**Summary of Oral Submissions at ISH10
Biodiversity and Ecology**

**for the
Royal Society for the Protection of Birds
and Suffolk Wildlife Trust**

**Submitted for Deadline 7
3 September 2021**

**Application by NNB Generation Company (SZC) Limited for an Order
Granting Development Consent for
The Sizewell C Project**

**Plate 1.18: Indicative lighting model for accommodation campus with the Bridleway maintained as a dark route**

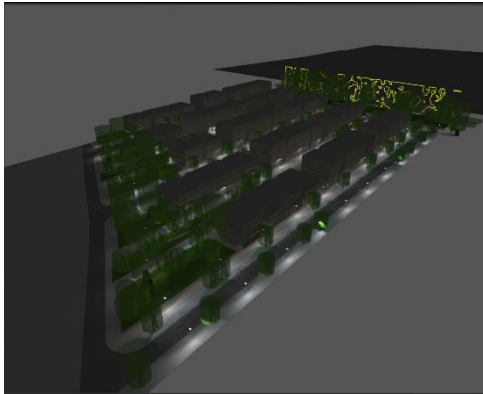
- 2.11 Our final point is on East Suffolk Council concerns over the mitigation. Most of the buffering of really important areas for barbastelle, in particular, is only 10m buffering from the point source of the light or noise pollution. This is a small amount of buffer, particularly along bridleway 19 which is a very important linear feature from Kenton woods up to Minsmere. That buffer is taken from the centre line of the bridleway rather than from the edge of the bridleway so in effect 10m in real terms is substantially less when you take it from the centre line of the bridleway. Dr Davidson-Watts did note that barbastelle forage within 25m of streetlights¹ which is an interesting observation but as far as we know there is no other observational data of barbastelle foraging closer than that, so we query how confident we can be that 10m is enough to buffer these important corridors. We also refer to recent published evidence (Boyes *et al*, 2021²) that strongly suggests a significant impact on caterpillars, the main prey items for barbastelle from LED lighting, with numbers reduced by up to 52%. Again, this suggests the current buffers of 10m will not be sufficient to prevent impact on foraging.

**Plate 1.20: Indicative lighting model for SSSI crossing**

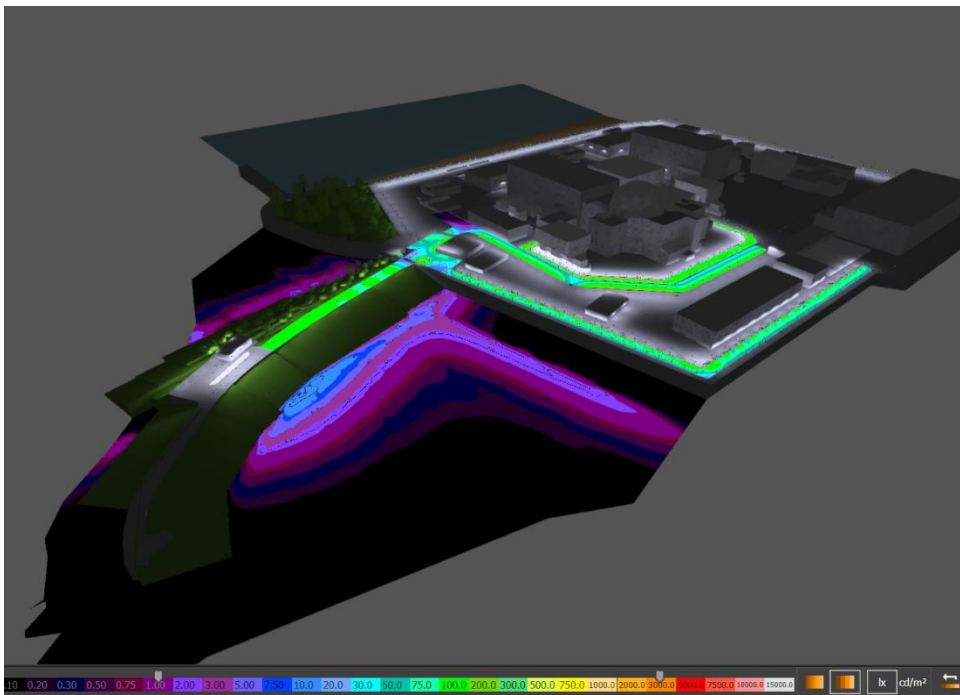
- 2.8 As far as we understand there has been no roost monitoring within the SSSI triangle where the SSSI crossing will go. We wish to reiterate our view that the lack of roost monitoring within the SSSI triangle, which is a very important area for barbastelle particularly, has always been something that has concerned us and which has then informed in our view that the mitigation package is not likely to fit with the overall impact of loss of roosts.
- 2.9 On the fragmentation for barbastelle, our view is that so far the assessments have not recognised the potential impact on juvenile and pregnant females which are around the Fiscal Policy, Goose Hill, SSSI triangle area. Pregnant female and juvenile bats have much reduced foraging ranges and we consider this has not been properly recognised and how the fragmentation effects may impact on successful birth and survival of the young.
